**Engineering and Technology Precinct Development
The University of Sydney, Darlington Campus (SSD 8636) - Notice of Exhibition**

Thank you for your letter dated 16 April 2018, requesting Transport for NSW (TfNSW) review and comment on the above.

SWEPT PATH ASSESSMENT

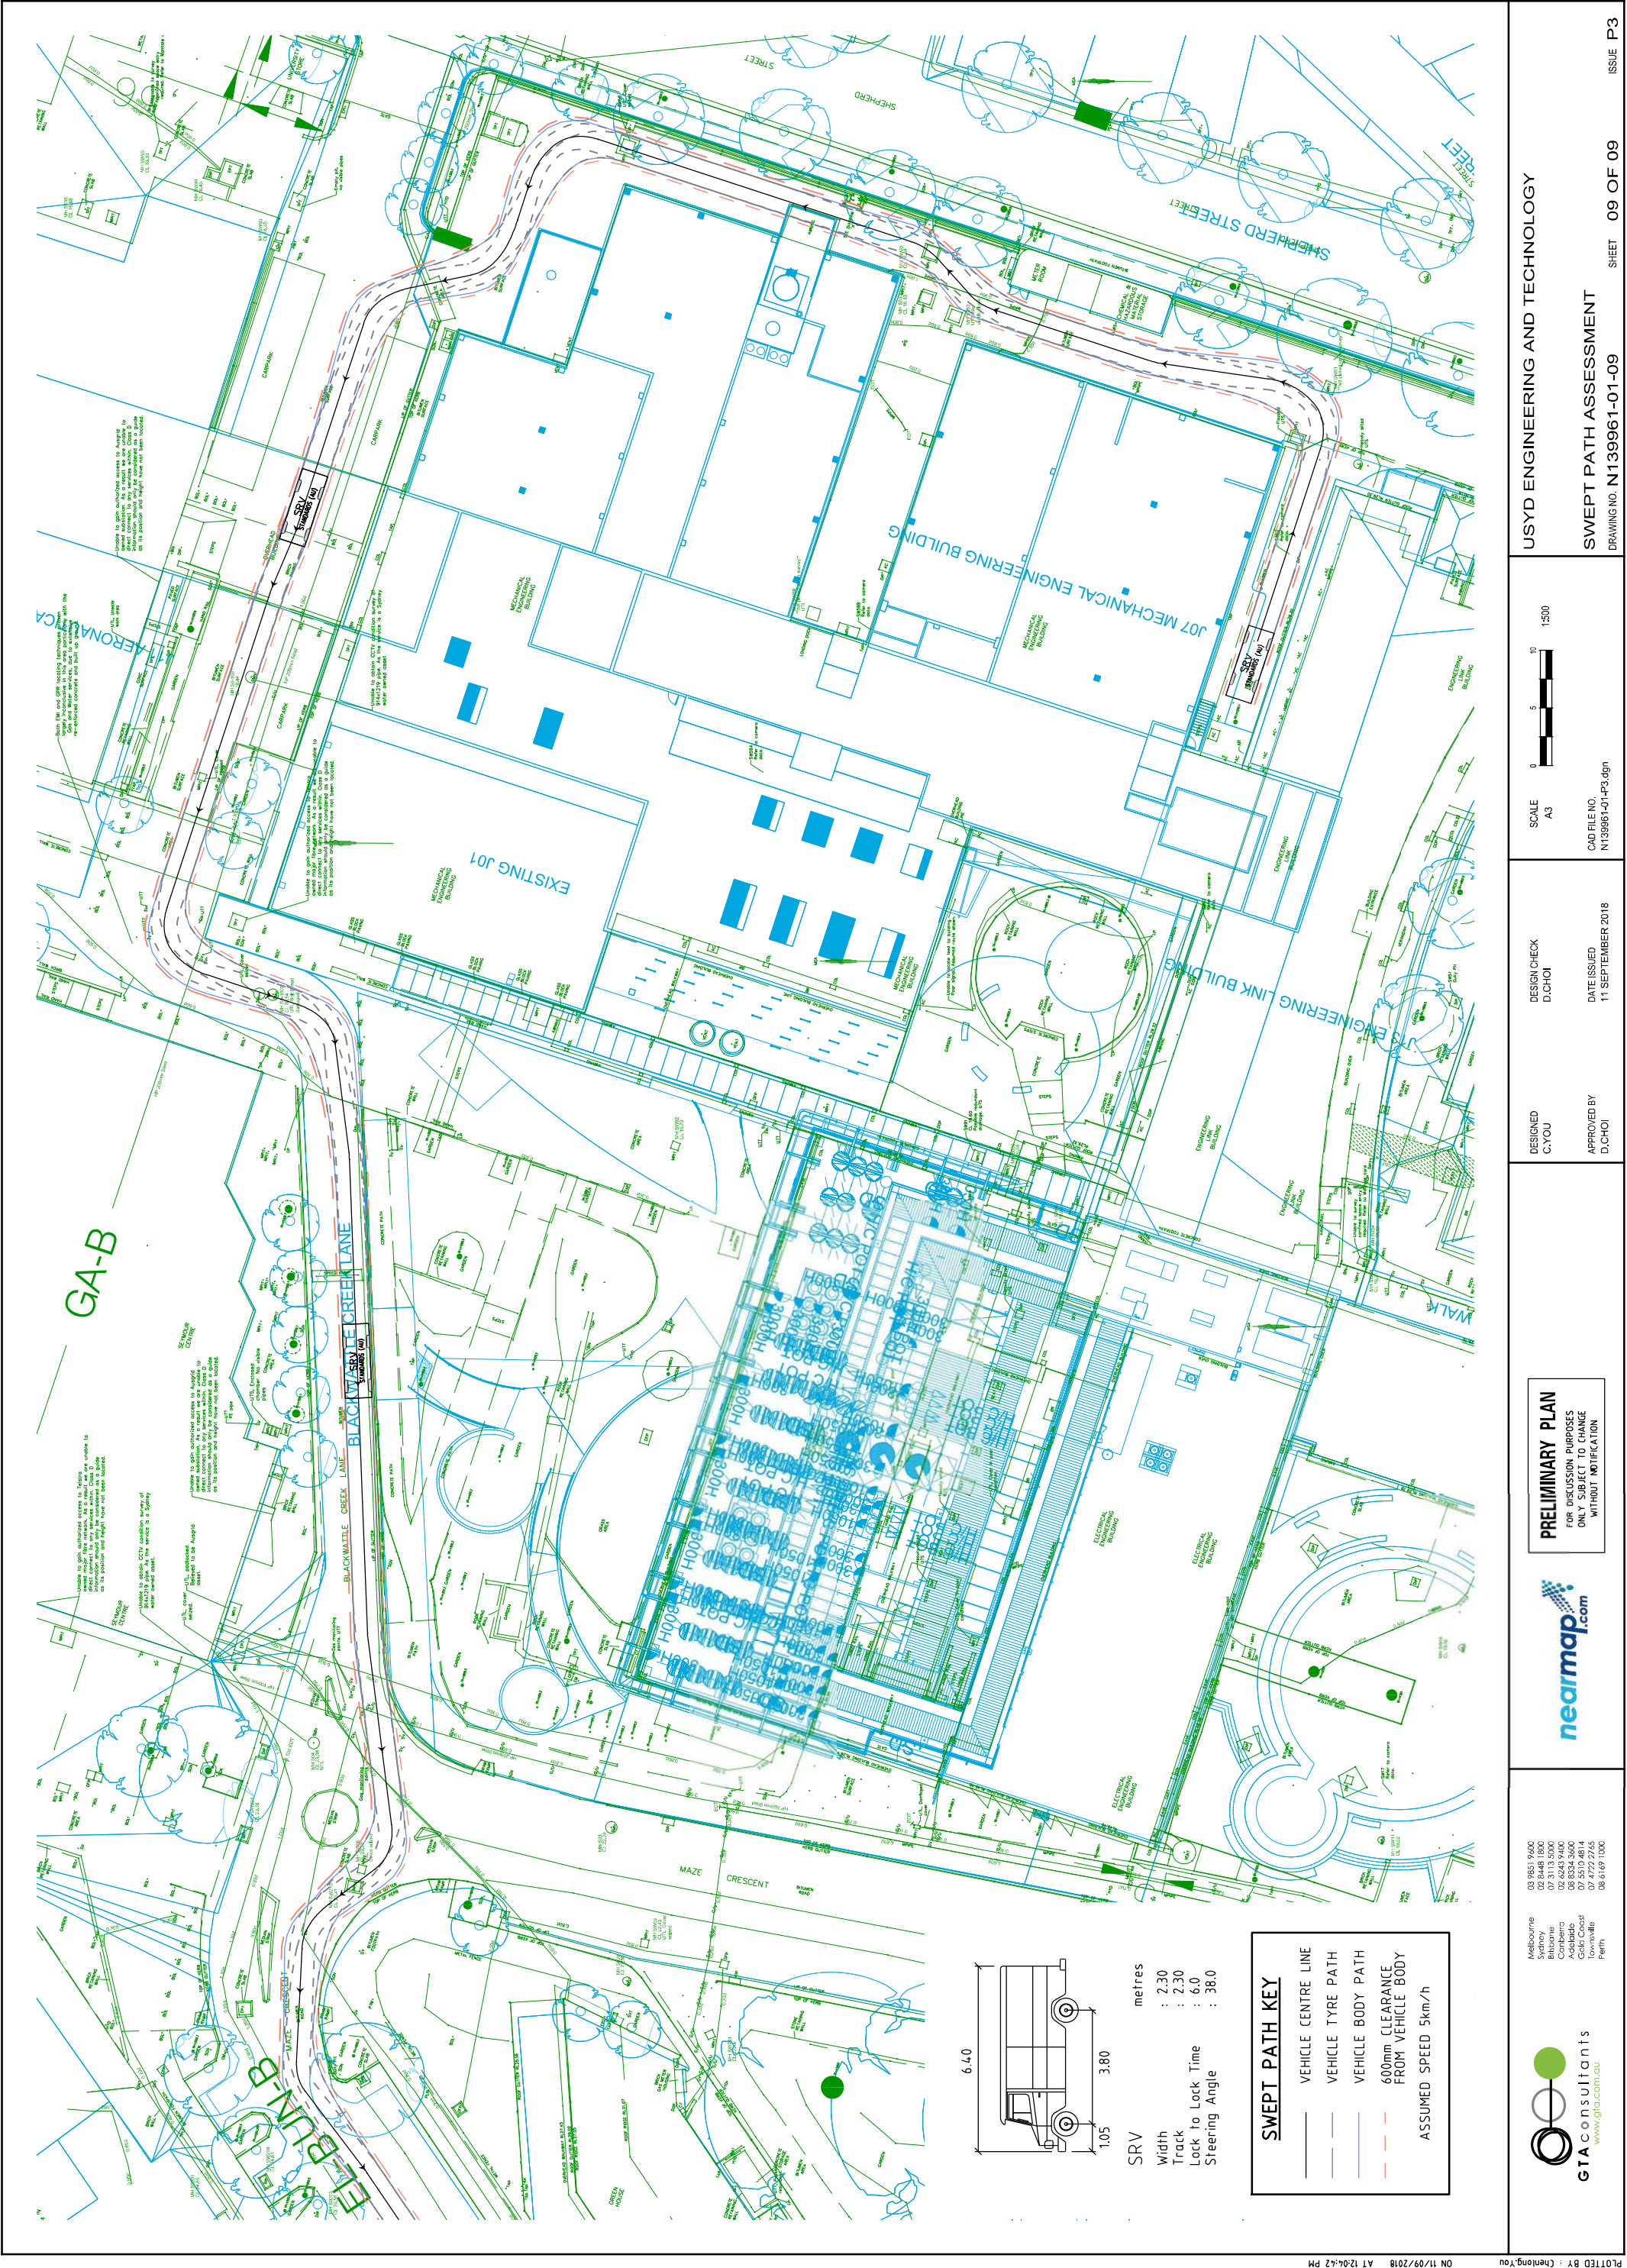
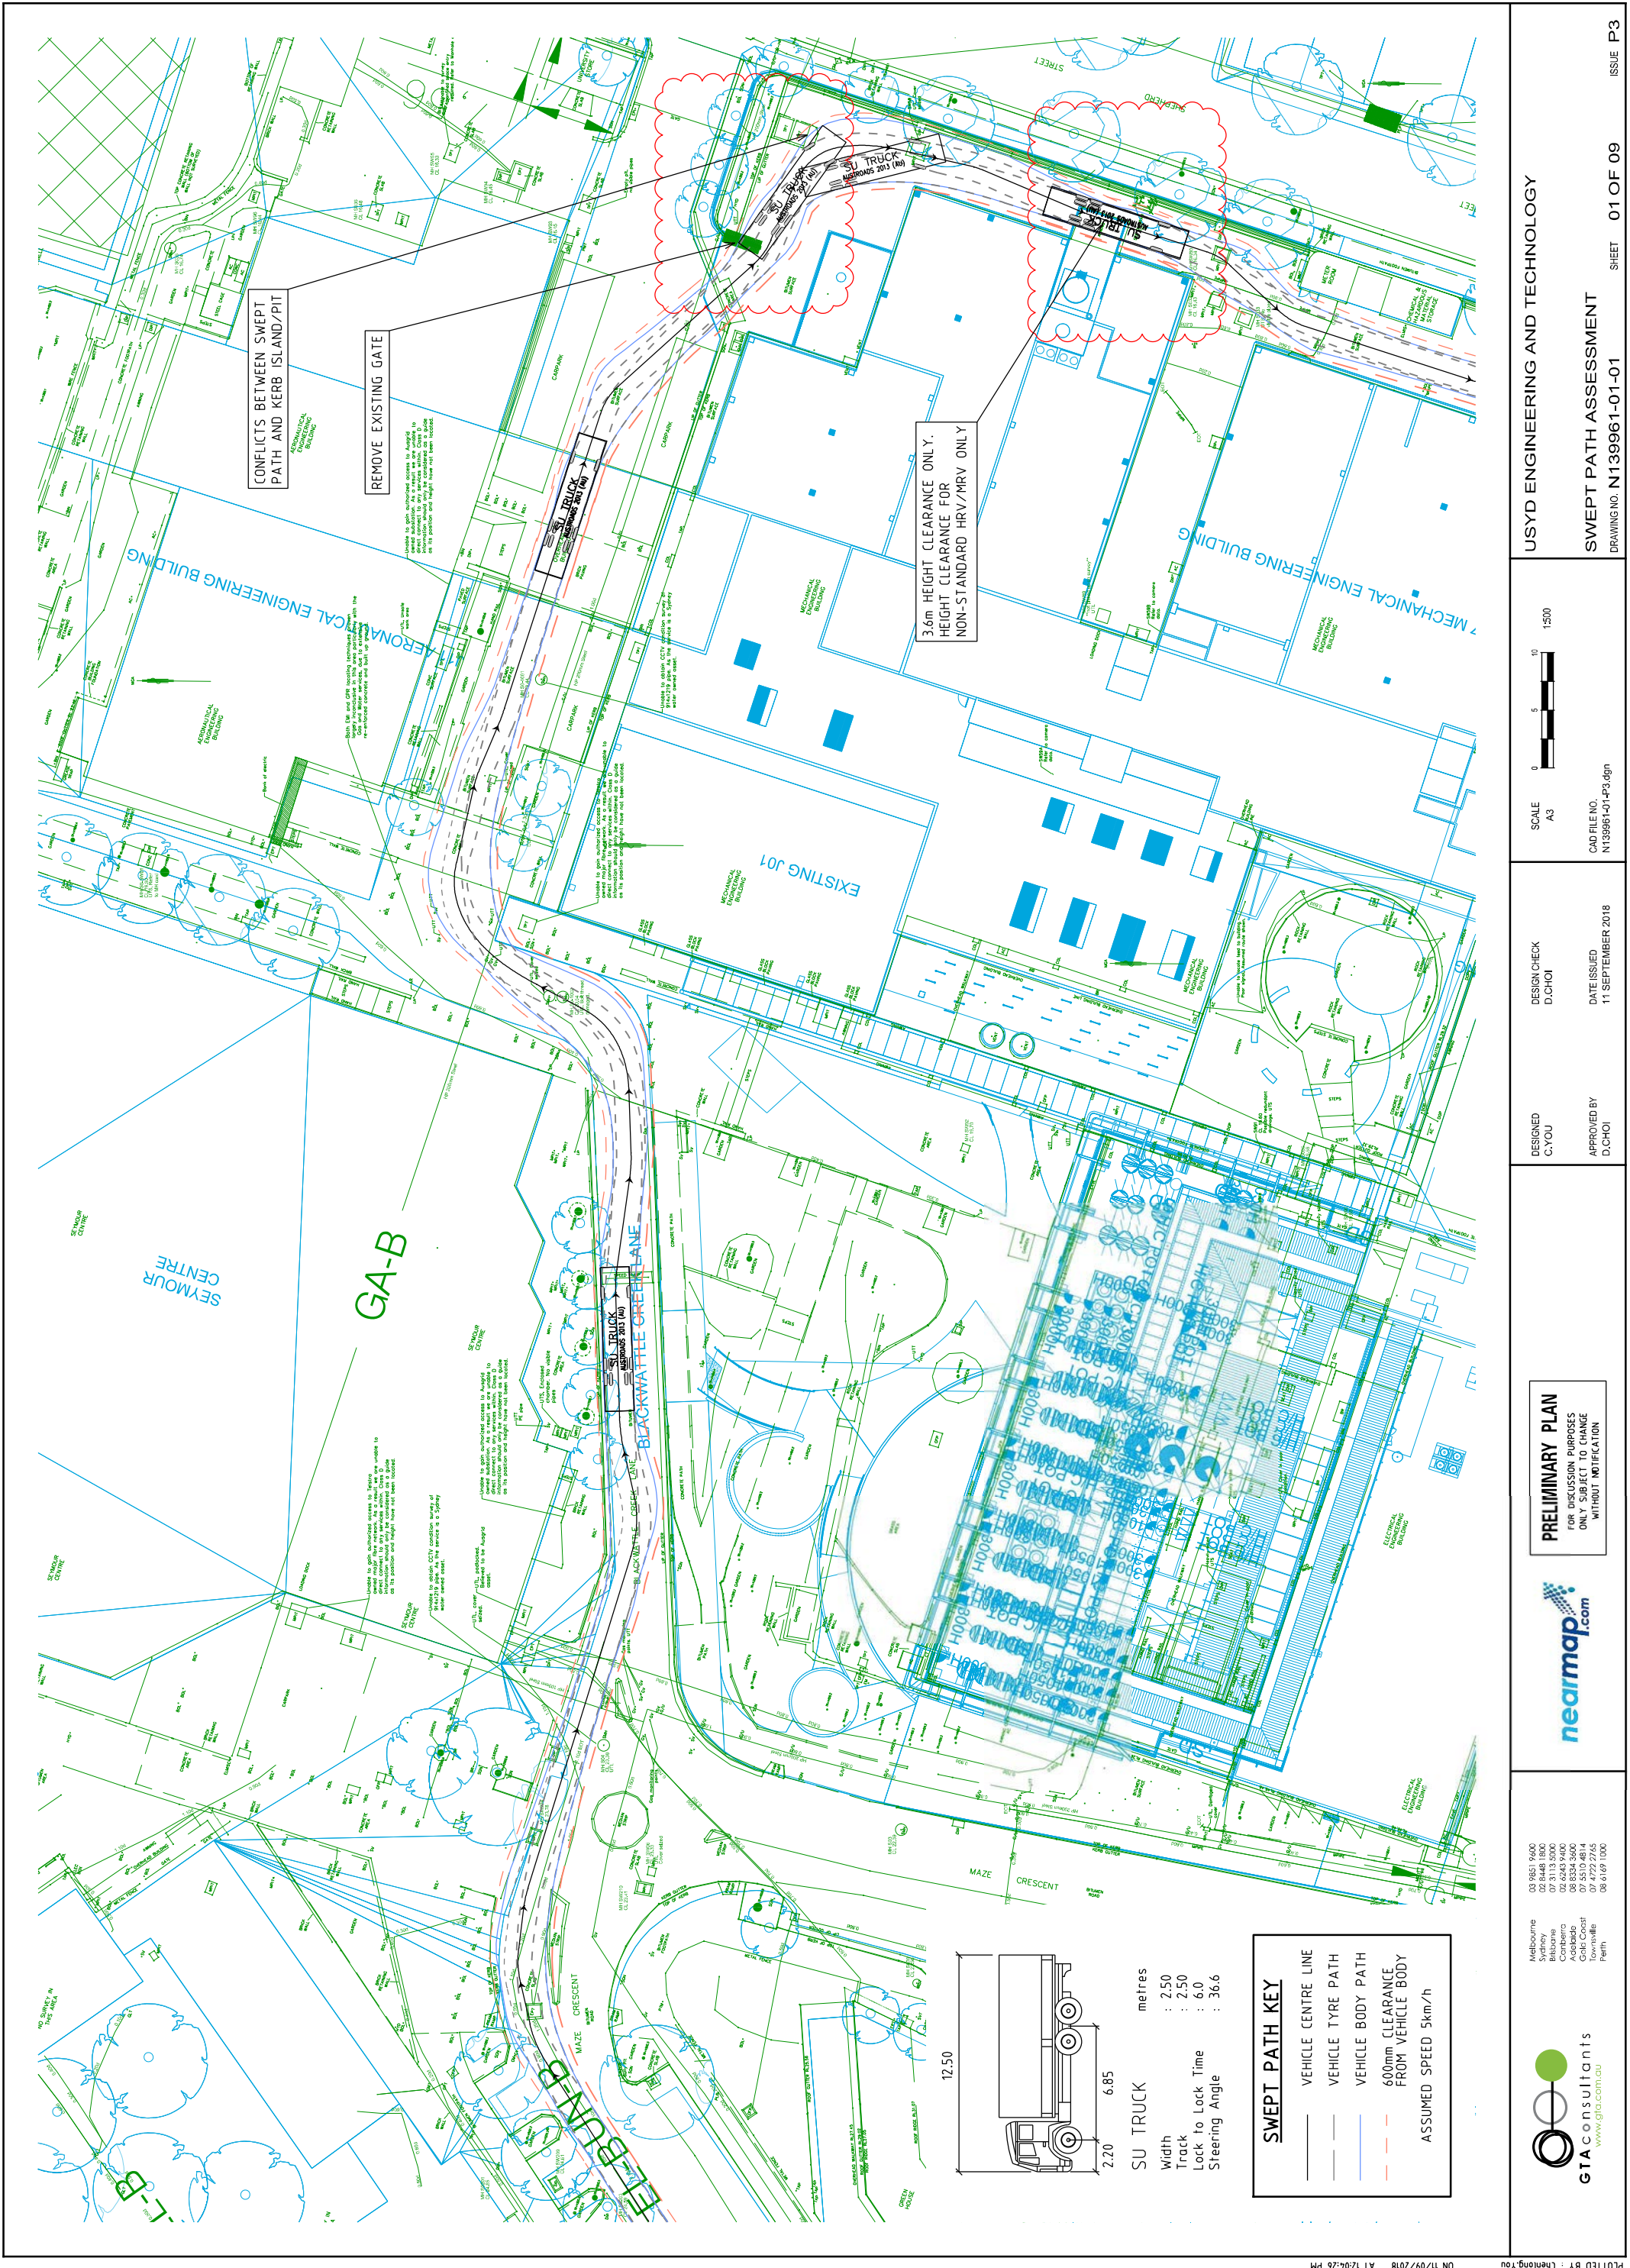
- The Traffic and Accessibility Assessment Report prepared to support the development application includes swept path analysis that shows a vehicle reversing into the loading dock. Proposed measures (other than signage) to manage the conflicts between reversing vehicles and pedestrians are not provided;
- The Swept path analysis needs to show servicing and loading vehicles accessing the proposed development from Shepherd Street; and
- No analysis has been undertaken to demonstrate the management of the loading dock, in particular the adequacy of loading dock and servicing arrangements to accommodate the future demand, ensuring all servicing and loading occurs on-site.

- Further details on how conflicts with reversing vehicles and pedestrians will be managed. If this conflict can't be adequately managed, the design should be modified to eliminate the need for reversing vehicles;

- Swept path analysis for servicing and loading vehicles accessing the proposed development from Shepherd Street. If access from Shepherd Street is to be restricted, details on how vehicles will be prevented from accessing the proposed development from Shepherd Street should be provided; and
- Loading bay management details including the adequacy of loading dock and servicing arrangements to accommodate the future demand and service vehicle movements during peak periods.
